Response to Planning application from Hertfordshire County Council (T and CP GDP Order 2015)

District ref: 6/2019/2714/OUTLINE
HCC ref: WH/312/2019
HCC received: 6 August 2020
Area manager: Roger Taylor
Case officer: Paul Marshall

YMCA, 90 Peartree Lane Welwyn Garden City AL7 3UL

Outline planning application for a hybrid application for demolition of existing hostel, development of a four storey 100 bed YMCA Hostel (All details submitted for determination) and a 2,3 and 4 storey building providing up to 43 residential apartments (All details retained for future determination as reserved matters, except means of access) with associated car parking and landscaping

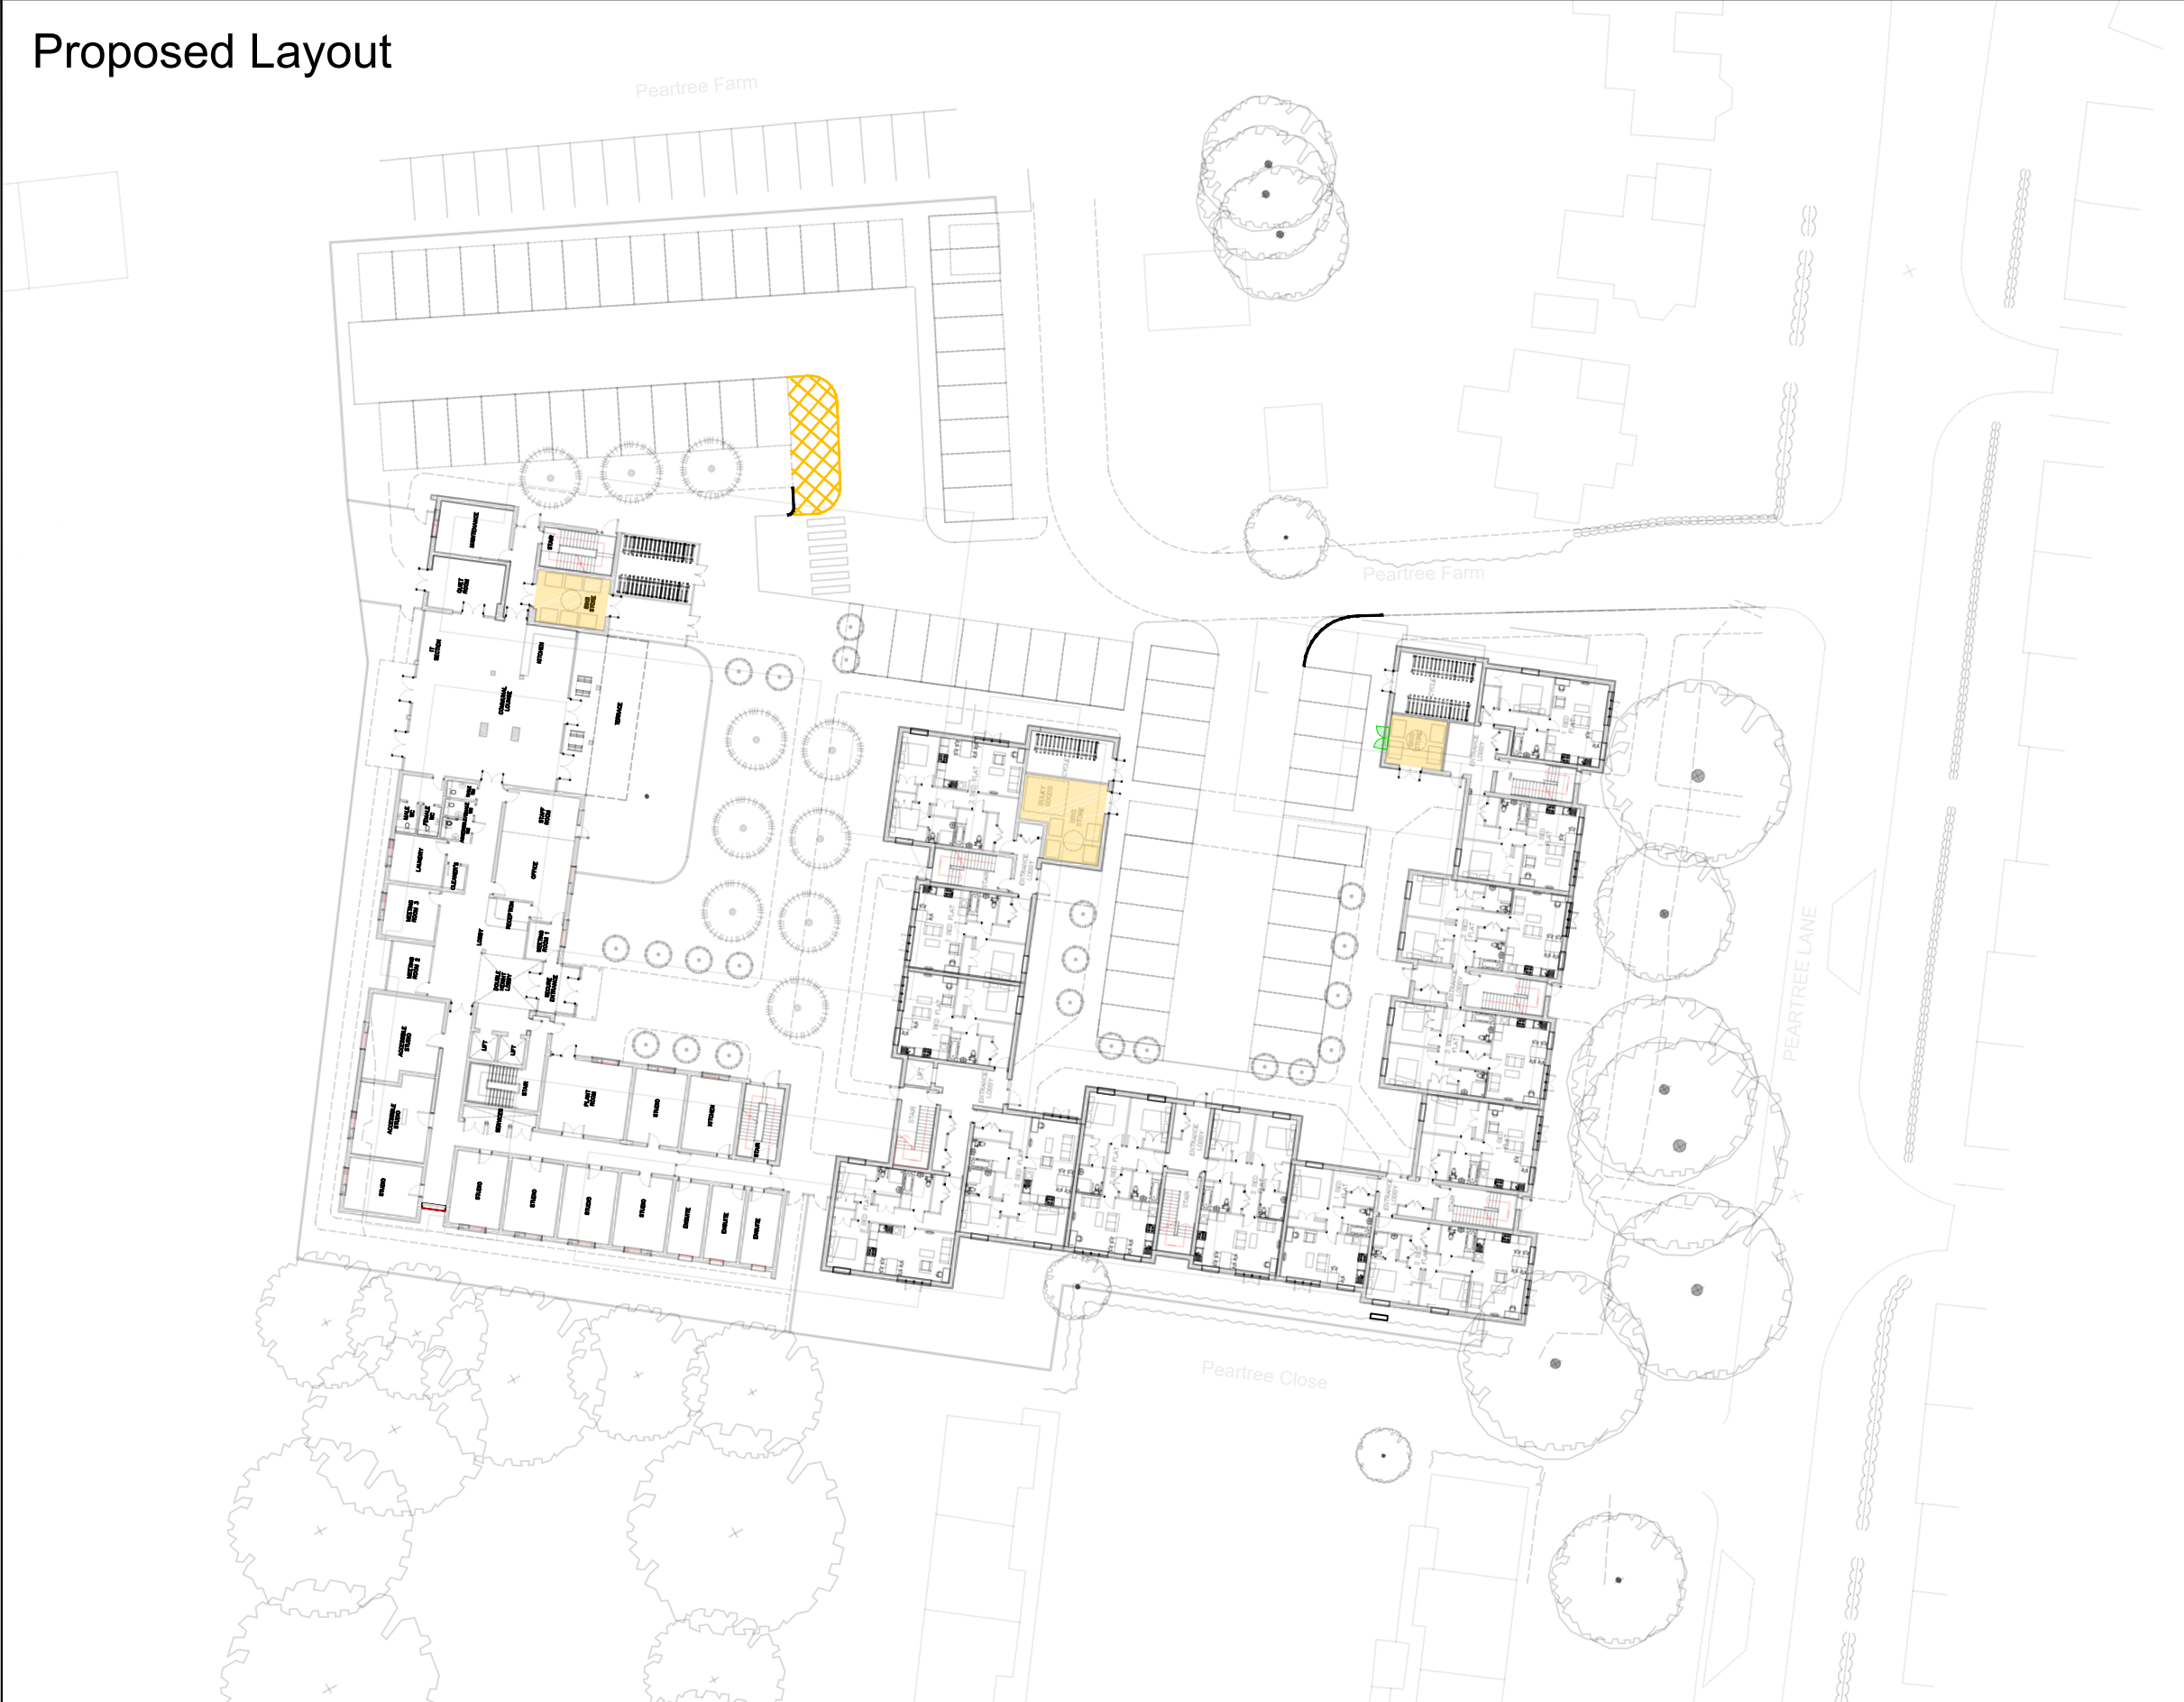
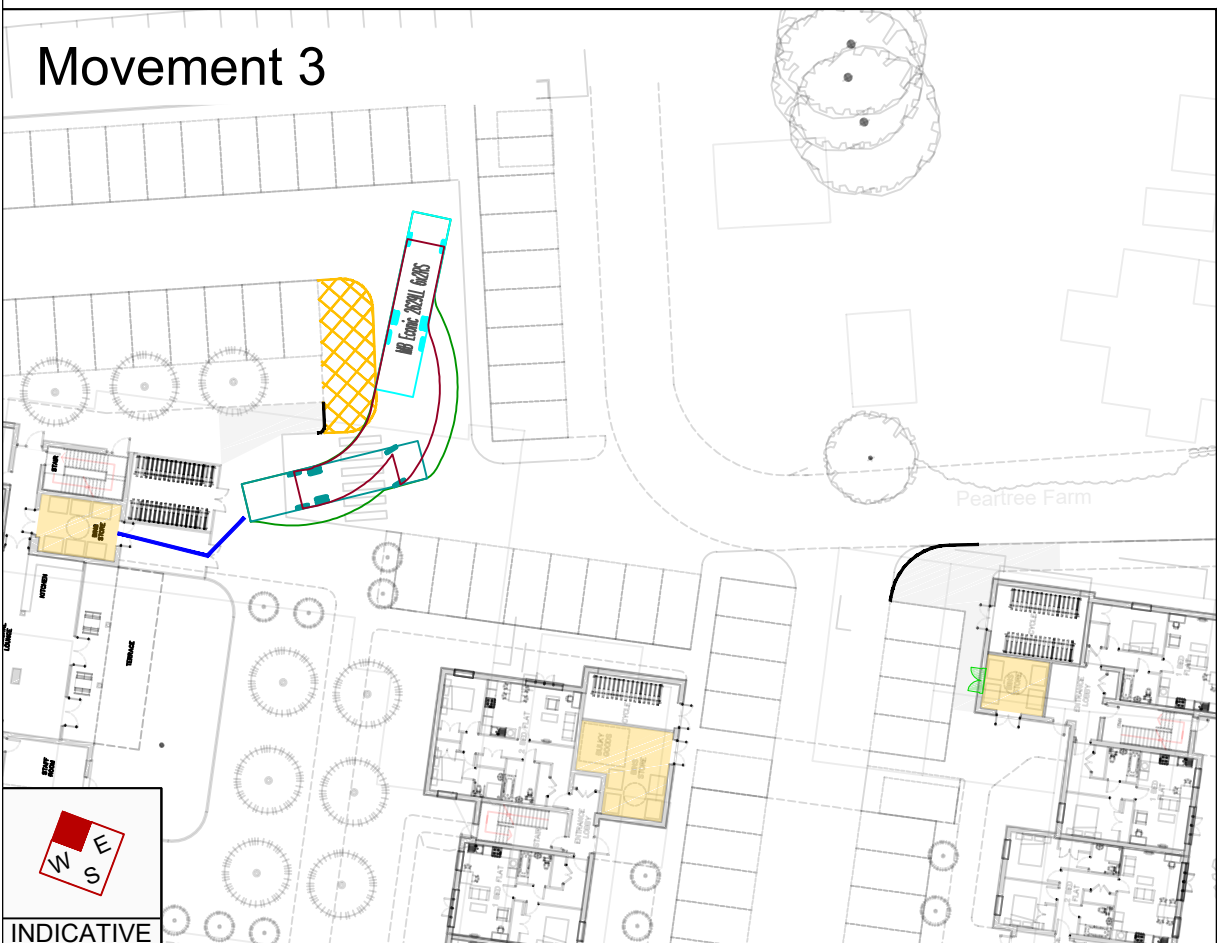
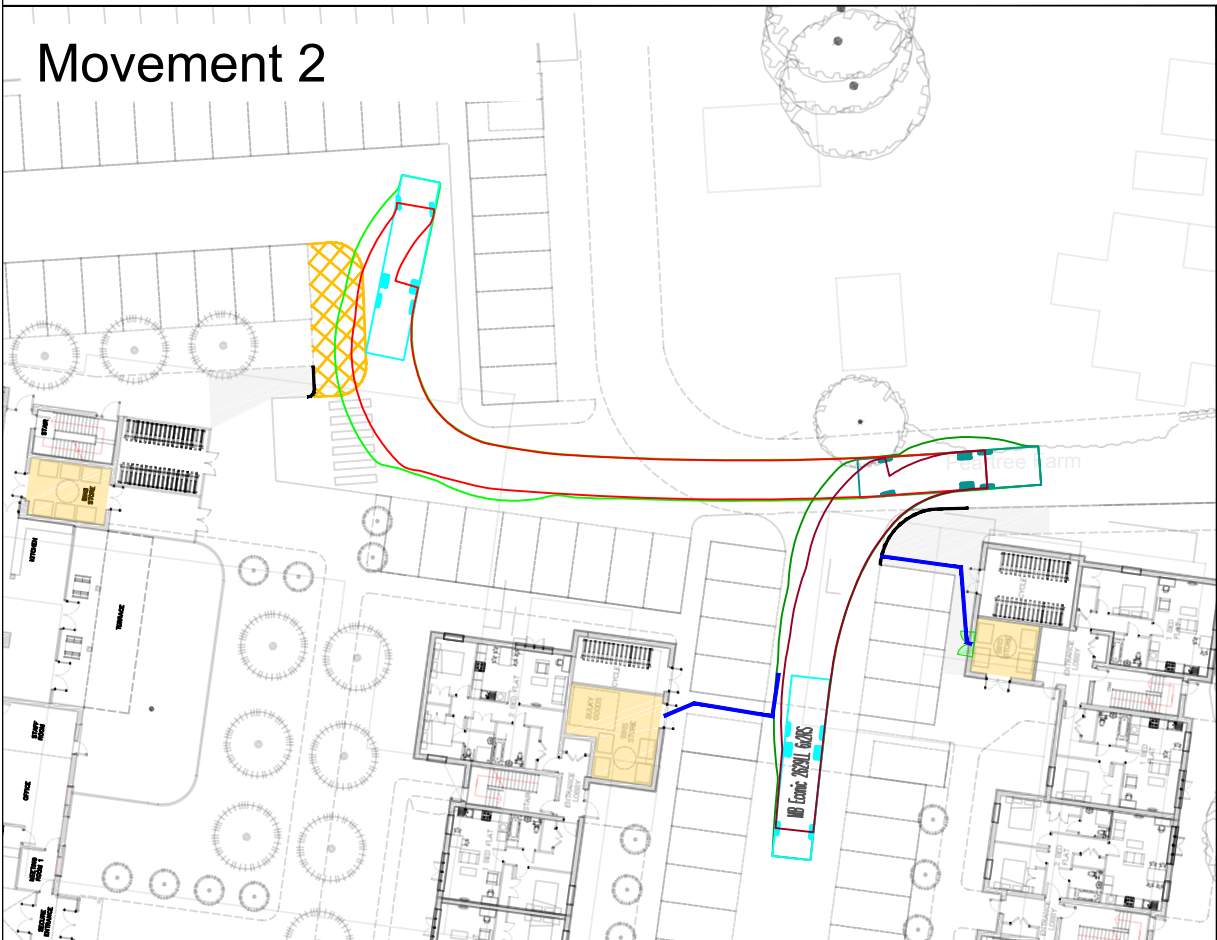
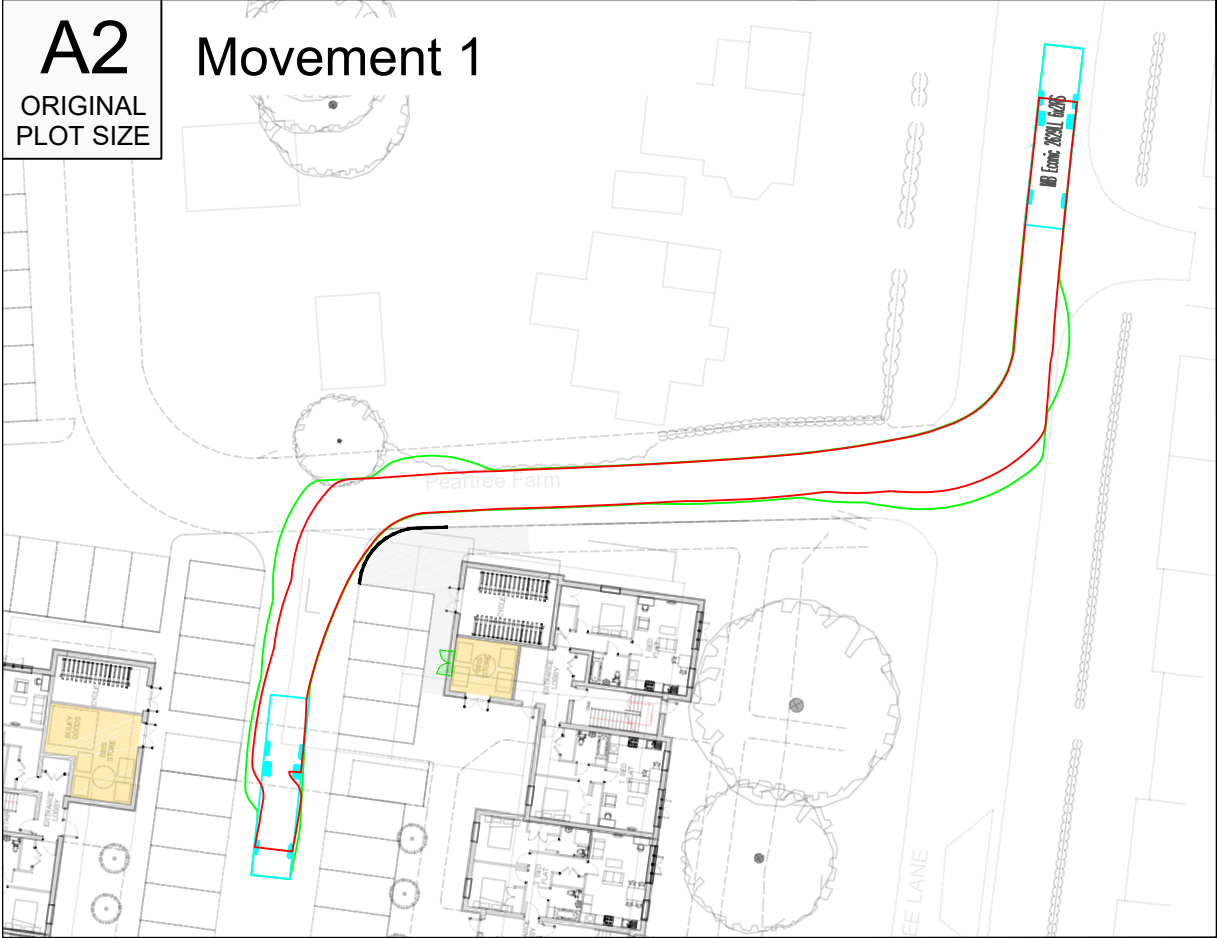
CON1) Existing Access: Improved: Prior to the first occupation of the development hereby permitted the vehicular accesses (indicated for improvement on drawing number 8057 P101 Proposed Site Layout) shall be upgraded to include tactile paving across the access on Peartree Farm and resurfacing of the bell mouth with Peartree Lane.

The proposed site layout has not been successfully tested with a swept path analysis on (drawings SP01,2, and 3 A) with a waste collection vehicle (11.2m long). Vehicles should be a minimum of 12.1m

The internal roads cannot accommodate manoeuvring space for waste collection vehicles (12.1m refuse vehicle). The proposed residential units meet the requirements for waste storage.
